16th June 2021

Antony Witherdin
 Director – Key Sites Assessment – DPIE
 City of Sydney
 456 Kent Street, Sydney
 NSW 2000

City of Sydney Review Response: Northern Precinct - Waterloo Metro Quarter

SECTION D 1:50
L13 COMMUNAL TERRACE

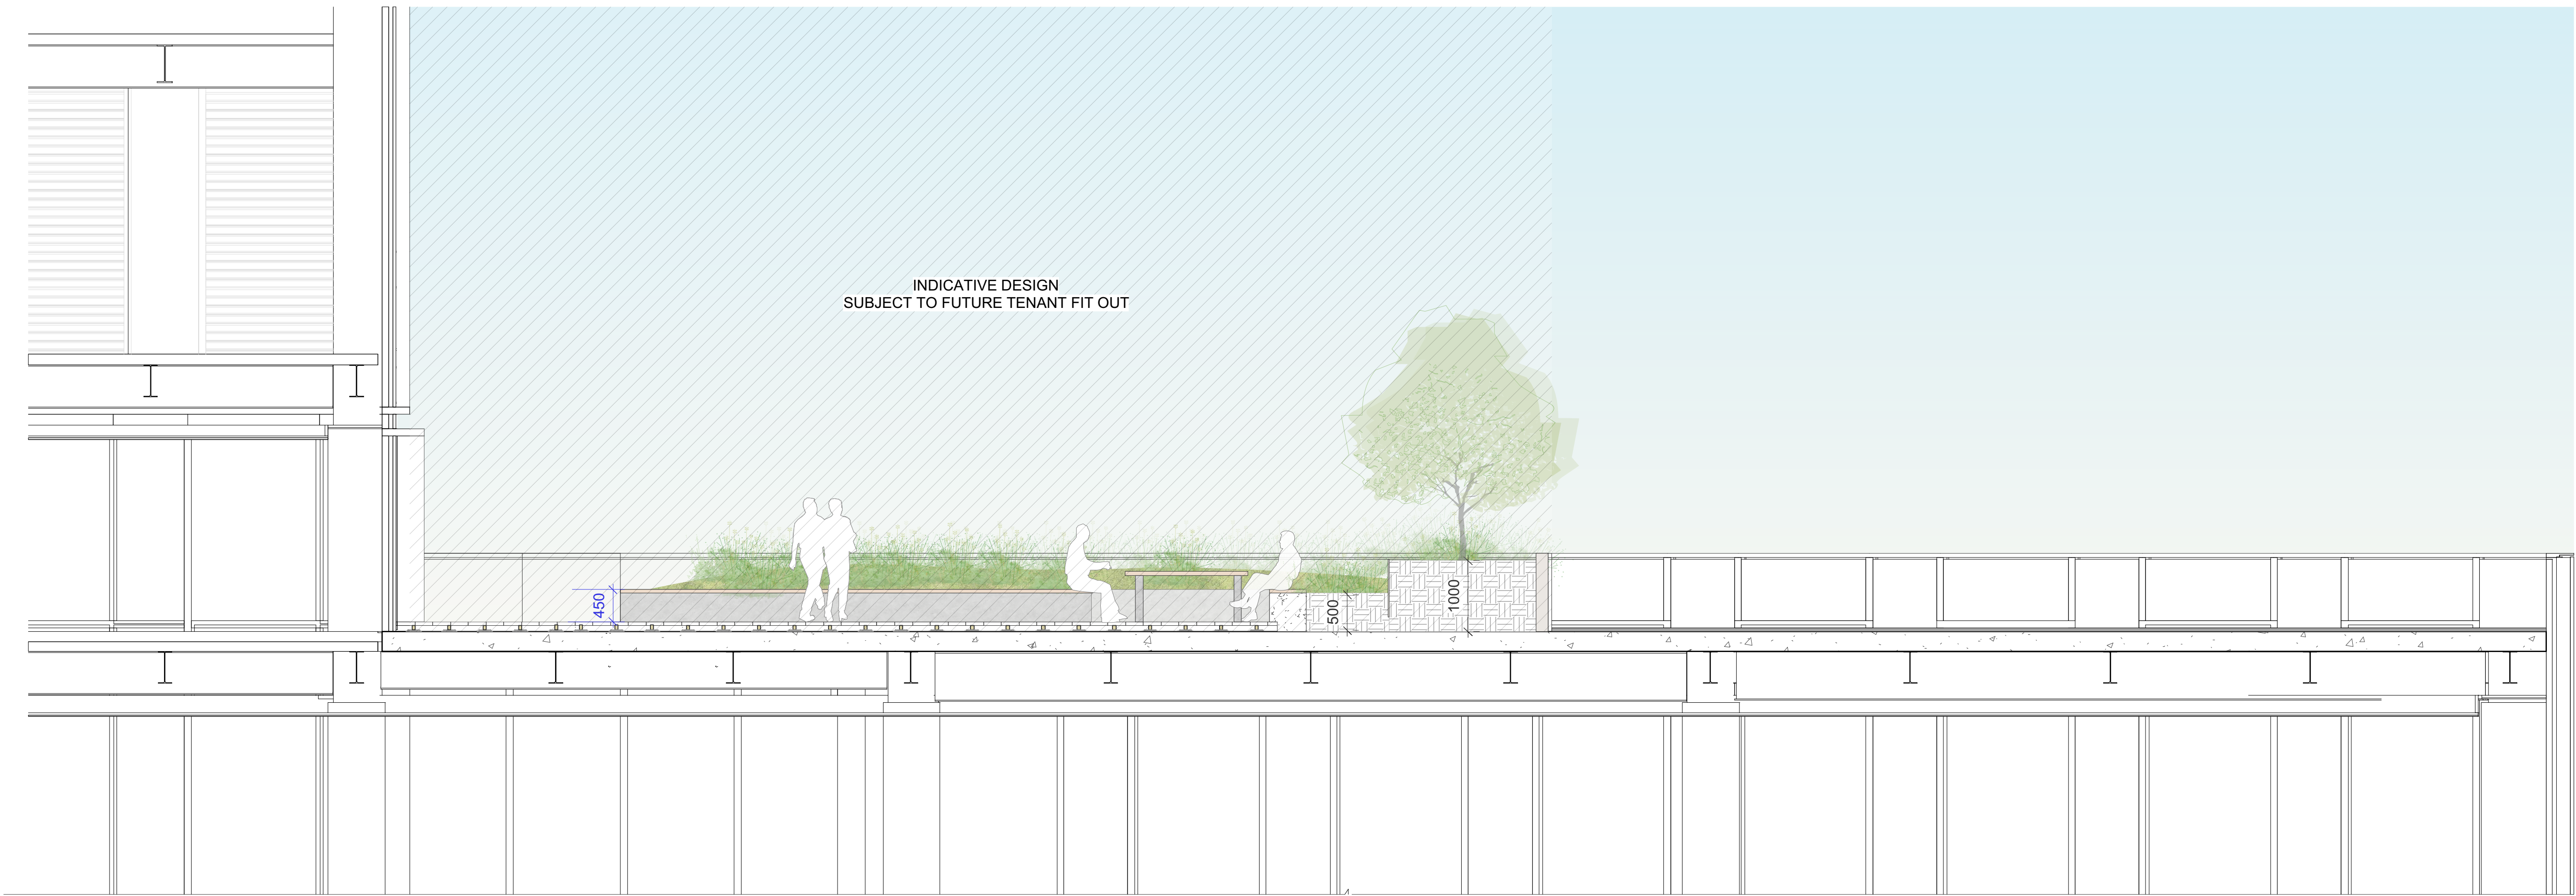
Landscaping		
17	<p>As previously stated, the development relies heavily on the success of tree planting to mitigate wind impacts caused by the buildings. It is imperative that all the recommendations of the wind report are incorporated into the conditions of consent.</p>	<p>Noted – Wind report recommendations have been incorporated. Please refer to response 4.</p>
18	<p>Section D on landscape drawing WMQ-BLD1-ASP-LS-DRG-DA-301 indicates that substantial soil mounding is relied upon to achieve the required soil depth for trees. Mounding of this extent is not supported, and it is recommended that the wall height be increased to these planters, limiting mounding to 300mm maximum.</p>	<p>Noted – The design of this space has been updated and no longer requires mounding to achieve the required soil depth. As per the <i>Landscape Code Vol 2 – Planting on Structure</i> – we will provide a minimum 900mm of soil depth as part of a large continuous planter for small trees 4-6m in height. Refer to updated section for design intent.</p>
